Supplementary Key Issues

The Department request that the Submissions Report clarifies what work has been undertaken since the MEOI report to support the current Proposal, including but not limited to:

FIGURE 2-3: OCEAN OUTFALL PIPELINE - SECTION 1 (BELOW GROUND)

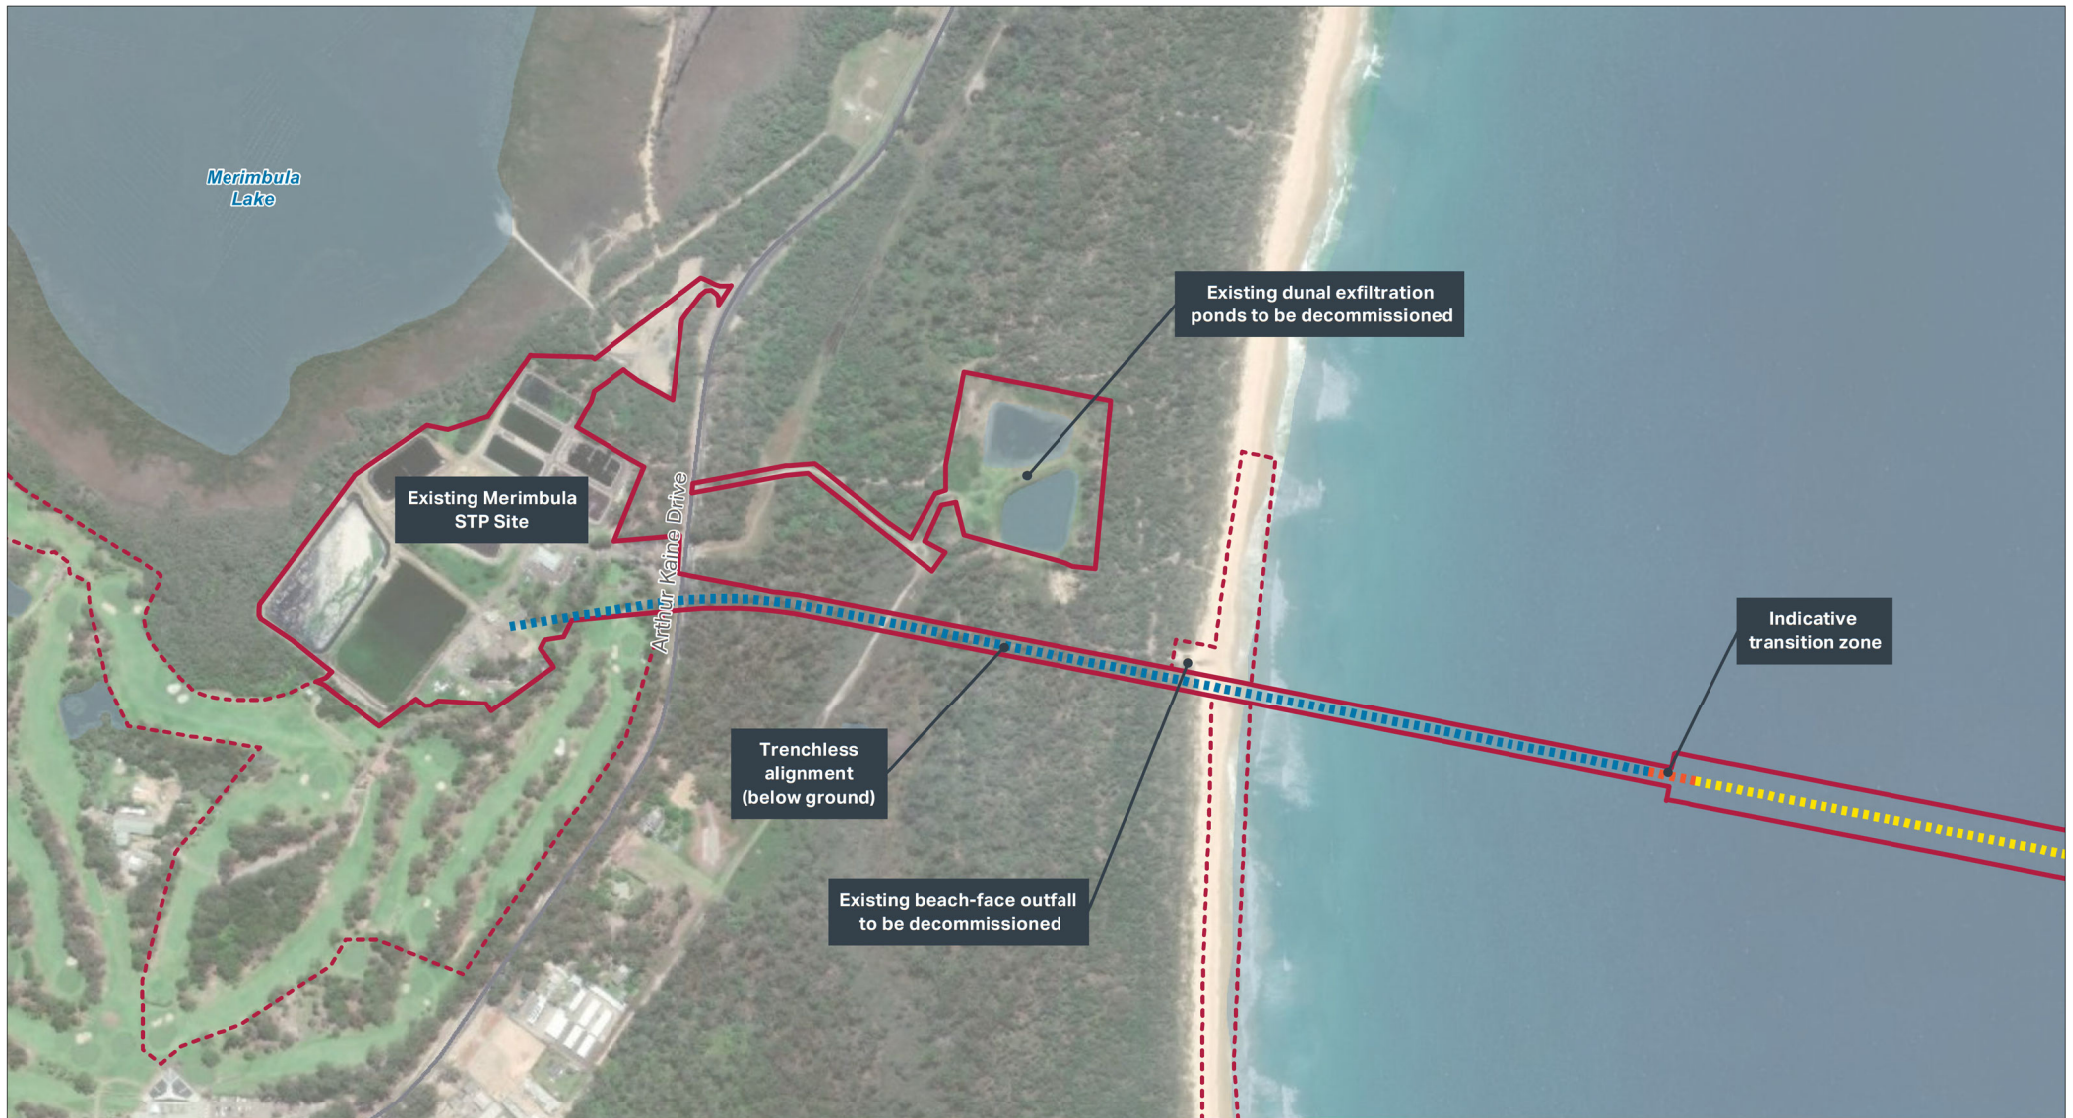
The Submissions Report must clarify the depth in which directional drilling will occur for the ocean outfall pipeline in the dune ridges as there is an inconsistency between the depths reported in the EIS and the Aboriginal Cultural Heritage Assessment Report (ACHAR).

Section 2.2.1 of the EIS states that 'the terrestrial component of the outfall pipeline would be laid between -9.3 m and -19.5 m AHD', whereas section 9.3 of the ACHAR notes the upper limit of drilling depths within dune ridges and the back barrier sand flat will be approximately 2m to 7.5m.

As the ACHAR notes that Aboriginal burial sites have previously been recorded within the project area at a depth of 2m – 3m below the original ground surface (ACHAR, Table 11) and that the Merimbula Barrier sand mass have been identified as having high archaeological potential clarify this inconsistency.
